Our Ref: BR/278/19/NMA

Application for non-material amendment following planning permission BR/153/17/RES relating to changes to landscaping design

3 Southdown Road Bognor Regis PO21 2JS

Rev. -A-	4.10.2019	Planning changes	BRC
Project:	3 Southdown Road		
Drawing Title:	Landscape Proposals & Planting Plan		
Purpose:	Planning		
Dwg. No.	1022-5300	Tudor Homes (Sussex) Ltd.	
Scale:	1:100 @ A1	Date:	20-May-2017

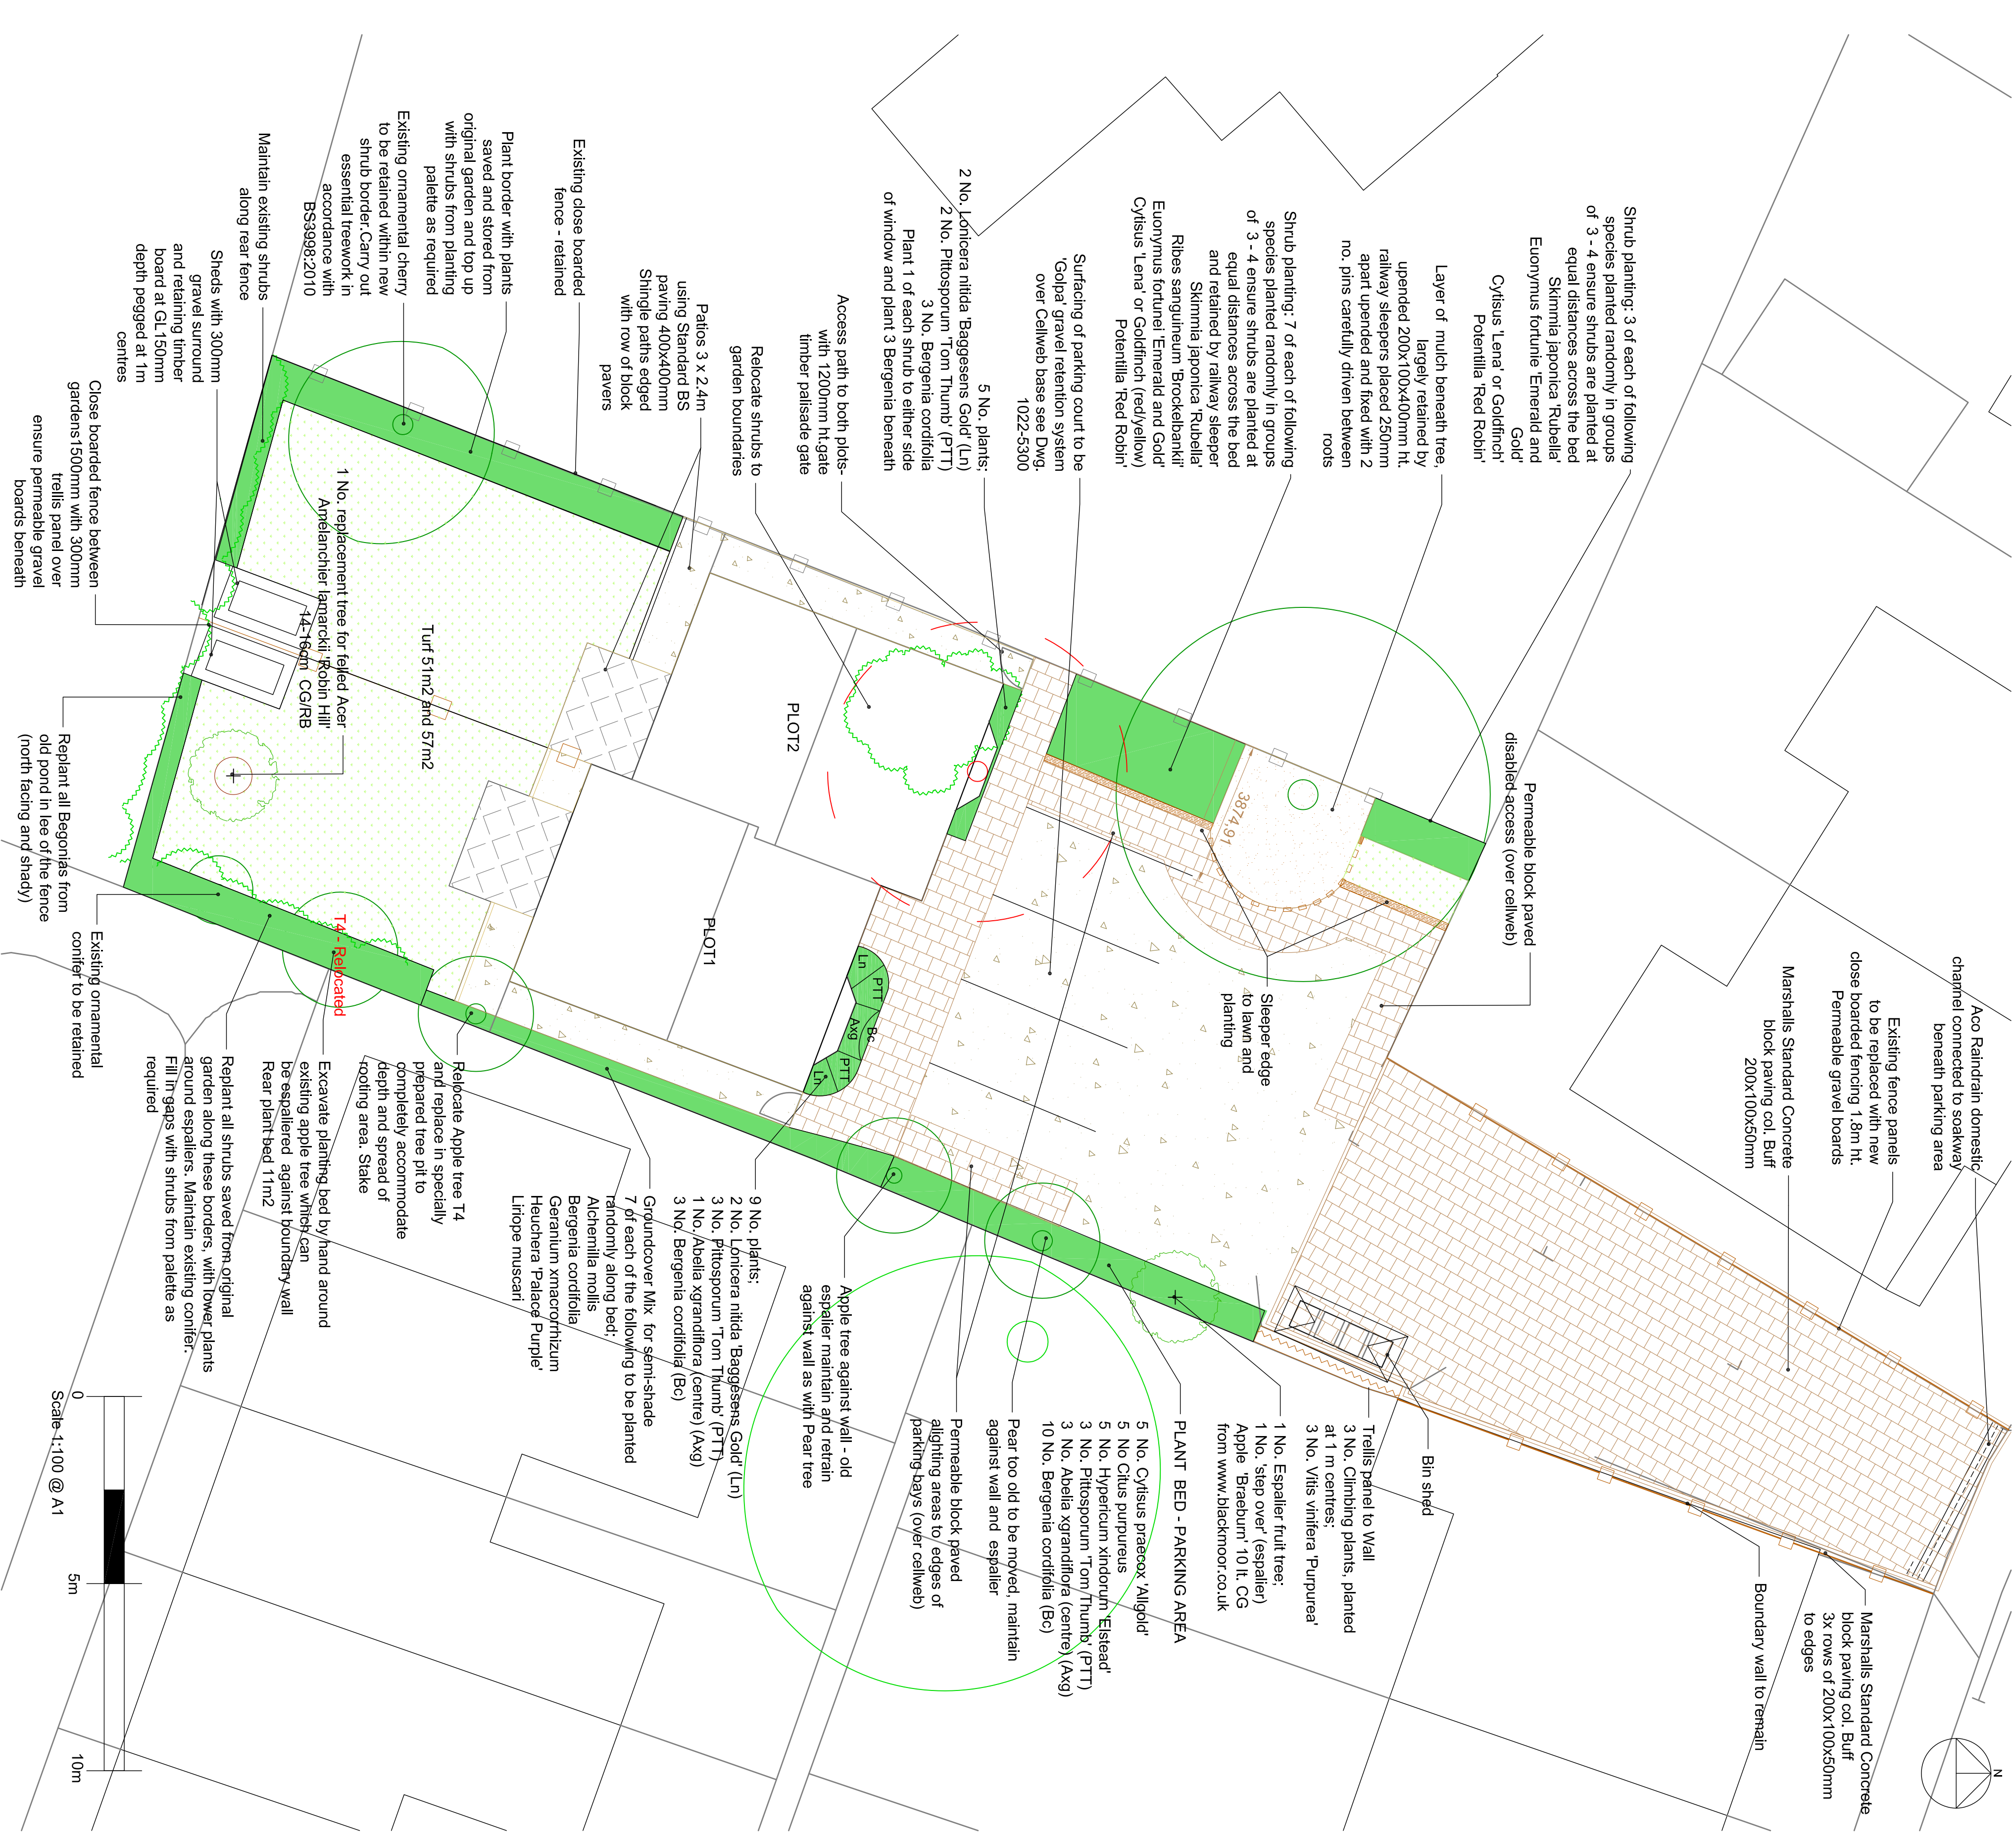
I refer to your recent application for a Non Material Minor Amendment. I note that you propose to change the finishes to parts of the driveway/hardstanding and also make some minor changes to the agreed planting.

There are no concerns with the changes to the planting scheme. However, we are unable to approve the changes to the hard surfacing, particularly to the driveway as these alter the details approved by BR/193/19/DOC in relation to the discharge of condition 07 and it would be necessary to consult with the Councils drainage engineers before such changes could be agreed.

The changes are therefore not considered to be a NMA under section 96A of the Town and Country Planning Act 1990.
